Submission No.			15	
Organisation Name or Name of Submitter			Barry and Aileen Dempsey	
Item No.	Section Ref.	Page No.	Observation Statement	TII Response
Re: Railway (Metrolink-Estuary to Charlemont via Dublin Airport) Order 2022 Case Reference Number NA29N.314724 16 th January 2023				
1	Letter	1	I am fully supportive of the development and implementation of a Metrolink project to connect the city centre and various existing transport routes to Dublin Airport. It is an essential component of a sustainable, efficient, lower-carbon transport infrastructure in the future. At the same time, we have reviewed the reports, proposals and supporting evidence and are firmly opposed to the siting of the terminus at Charlemont.	Thank you for taking the time to make a submission and your overall endorsement of the MetroLink Project with the exception of Charlemont Station. We have reviewed your submission and responded to the observations made below.

Submission No.			15	
Organisation Name or Name of Submitter			Barry and Aileen Dempsey	
Item No.	Section Ref.	Page No.	Observation Statement	TII Response
Re: Railway (Metrolink-Estuary to Charlemont via Dublin Airport) Order 2022 Case Reference N

Figure 5-1: Charlemont Station Layout at Surface

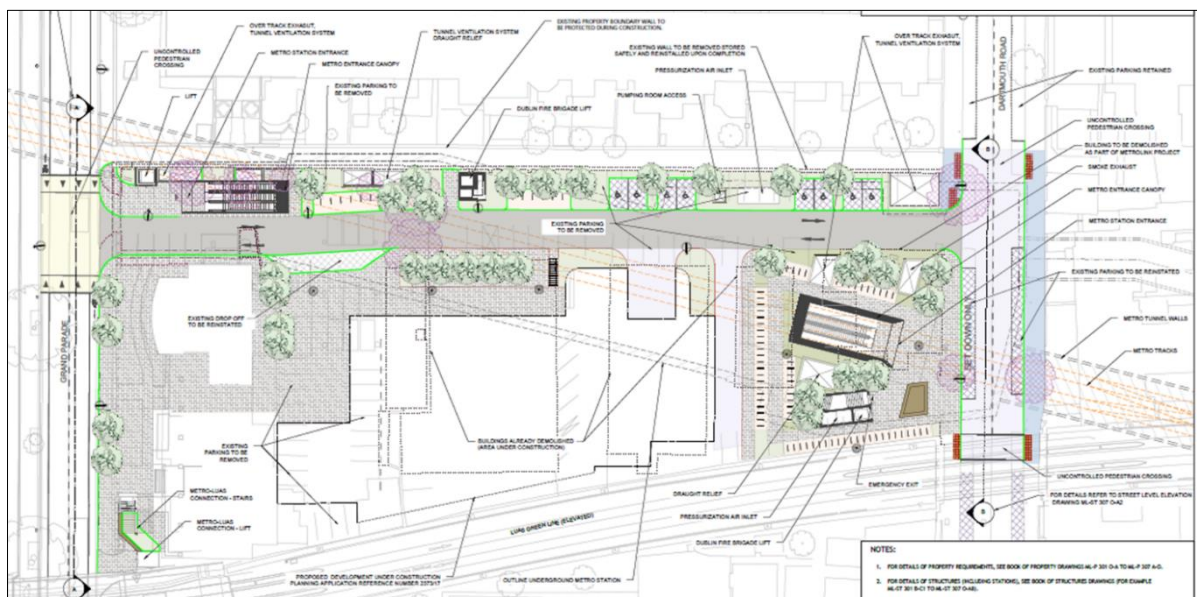
5	Letter	1	3. The station box at Charlemont, as constructed in 2021/22 by the developer Hines, does not have the benefit of planning permission and has not been part of the EIA undertaken for this project. Processing the current Railway Order application, which is reliant on these preliminary and now constructed works, is legally unsafe and contravenes the provisions of the EIA Directive.	The MetroLink enabling works constructed as part of the Hines development was included in the planning application for the Hines Development and has the benefit of planning permission which was granted in April 2019.
